Recommendation Report for Planning Permission for Works or Extension to a Dwelling

REF NO: AB/7/19/HH

LOCATION: Rose Cottage
72 Ford Road
Arundel
BN18 9EX

PROPOSAL: Construction of single storey rear extension and associated works

drawing
Floor Plans and Roof Plan
As Proposed

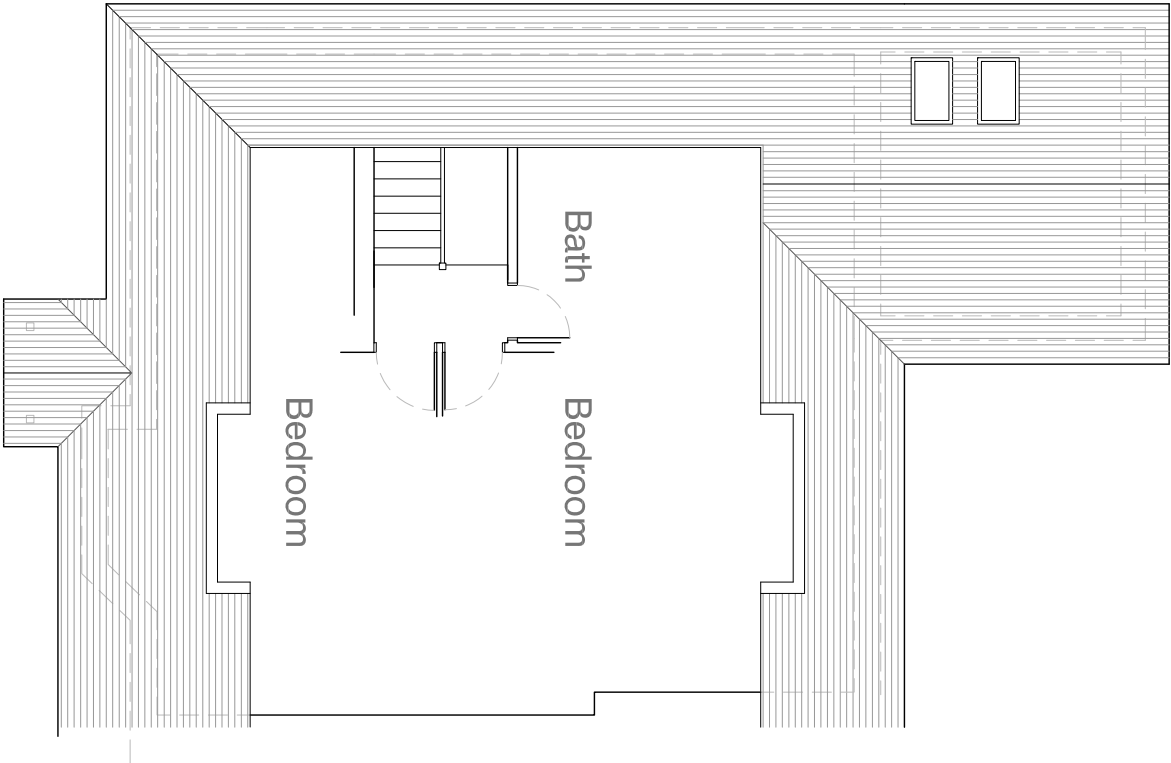
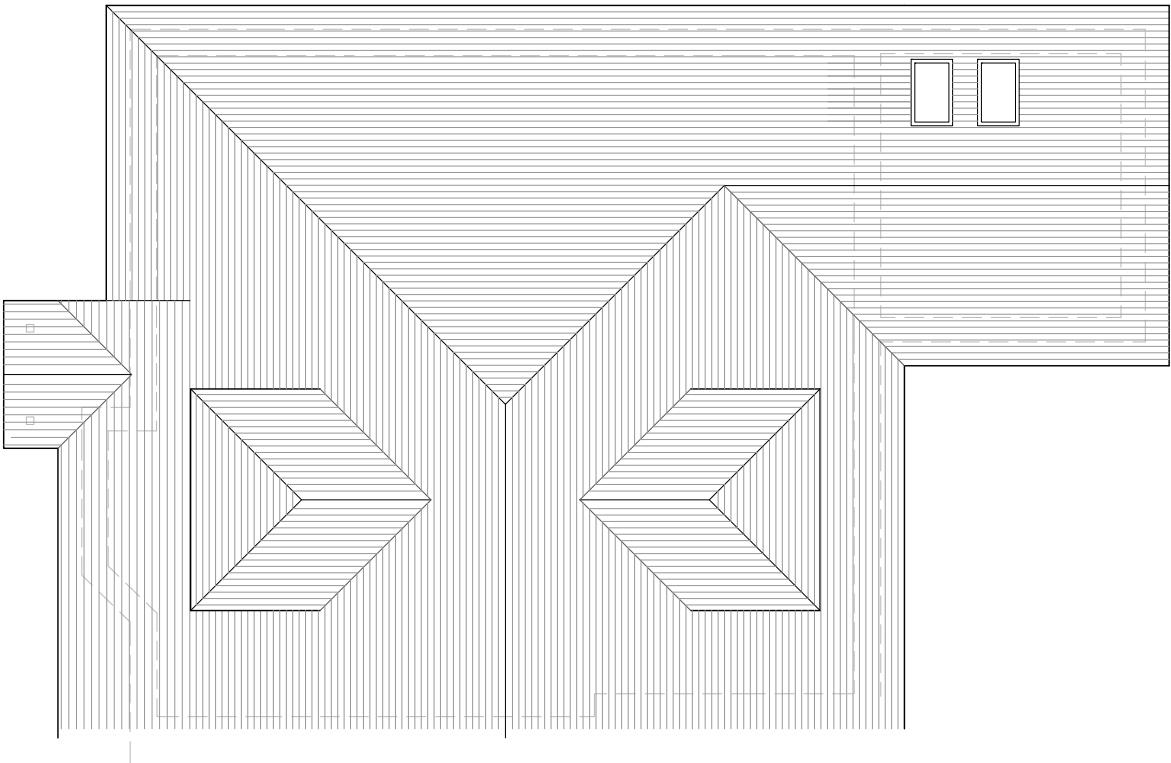
Given the distance from the bi-fold doors and the Northern boundary of the site is approximately 4.6m and they are at ground floor level, they will not give rise to any additional overlooking or loss of privacy to the neighbouring properties. The extension will also include 2 rooflights, however by virtue of the design of the proposed extension and the location of these windows, they will not result in any unacceptably adverse overlooking of neighbouring properties.

drawing	As Proposed
	Elevations and Typical Cross Section

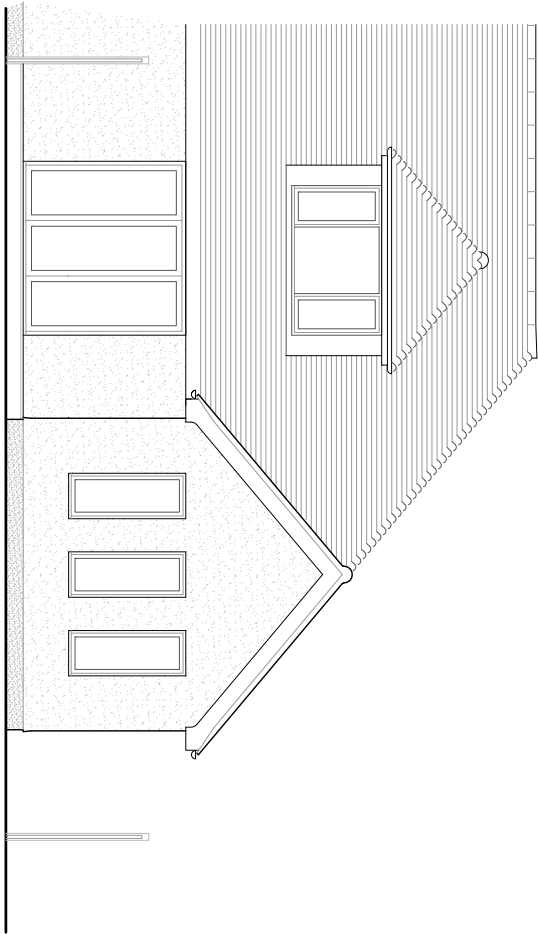
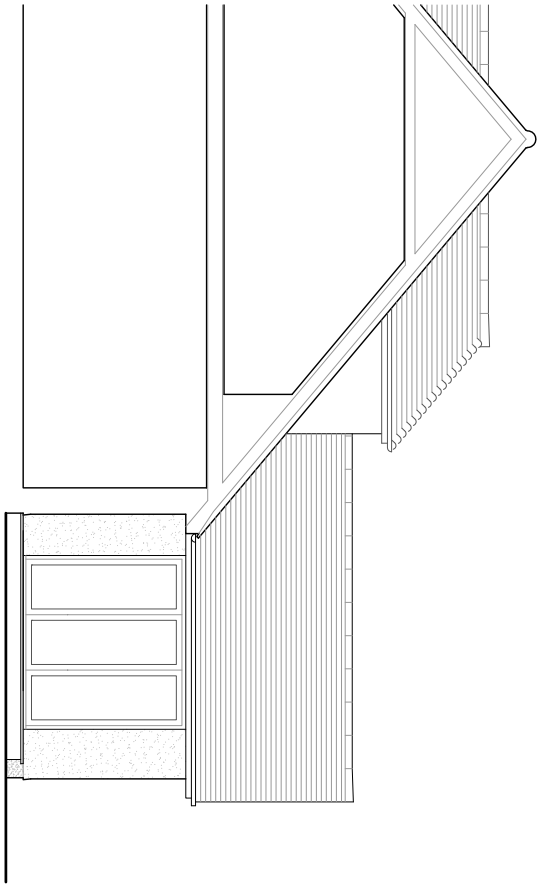
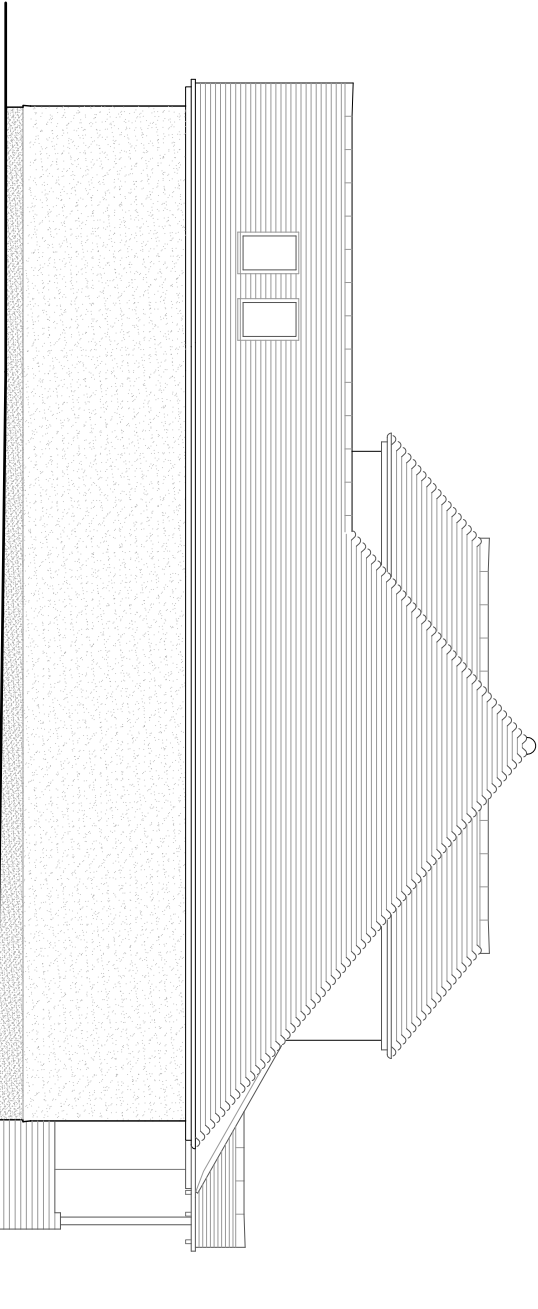
The single storey rear extension will be located approximately 4.6m from the Northern boundary, 1.3m from Southern boundary and 7.1m from the Western boundary. The proposed extension will feature 3 windows on the rear (Western) elevation and bi-fold doors on the Northern elevation. The windows on the Western elevations are not considered to give rise to any additional overlooking given they are on the ground floor and overlooking the rear garden. No windows have been incorporated on the southern elevation of the proposed extension to further mitigate any potential impact upon neighbouring properties.
